PLANNING CONSULTATION REPLY

APPLICATION: 3 Hawkwell Bank, Ardsley, Barnsley, S71 5DX.

P1

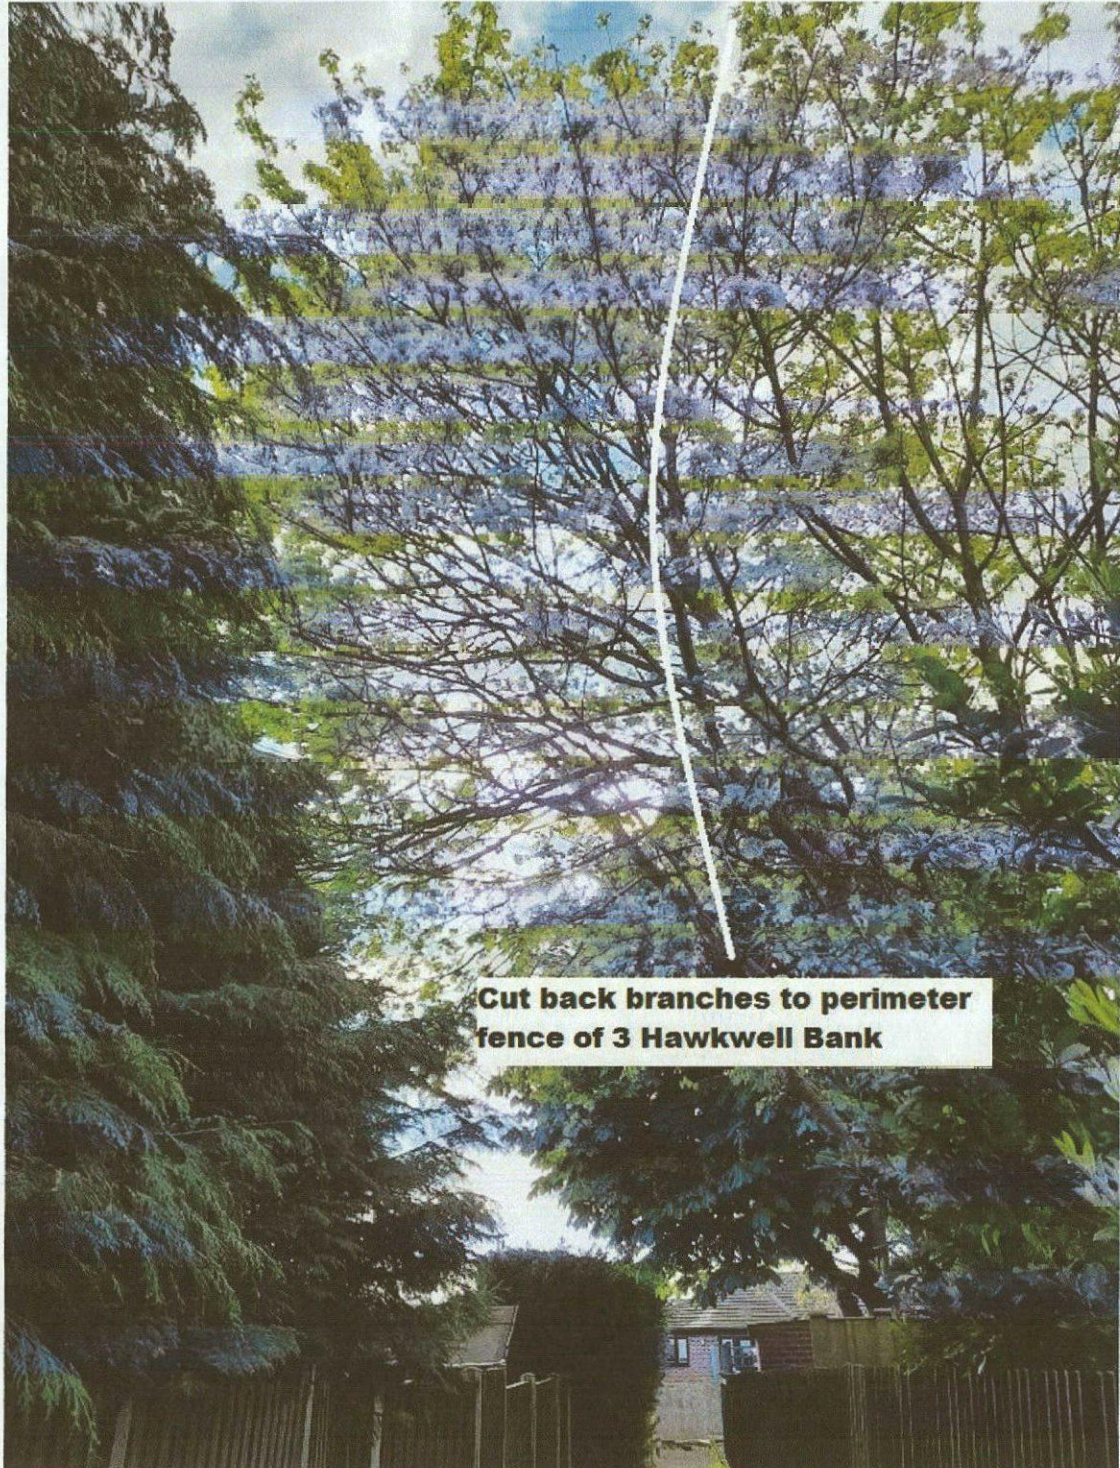
The works proposed originally were to prune the tree back to clear both the applicants garden and the path. This would have removed a significant amount of the trees leafing area and as such could not be considered acceptable. As such a new works description has been agreed upon which is to reduce the trees canopy back towards the boundary from over the garden of 45 Cumberland Drive to suitable pruning points.

These works are within the limits of what can be considered acceptable and as such I can confirm I have no objection to the works as detailed in the amended works description.
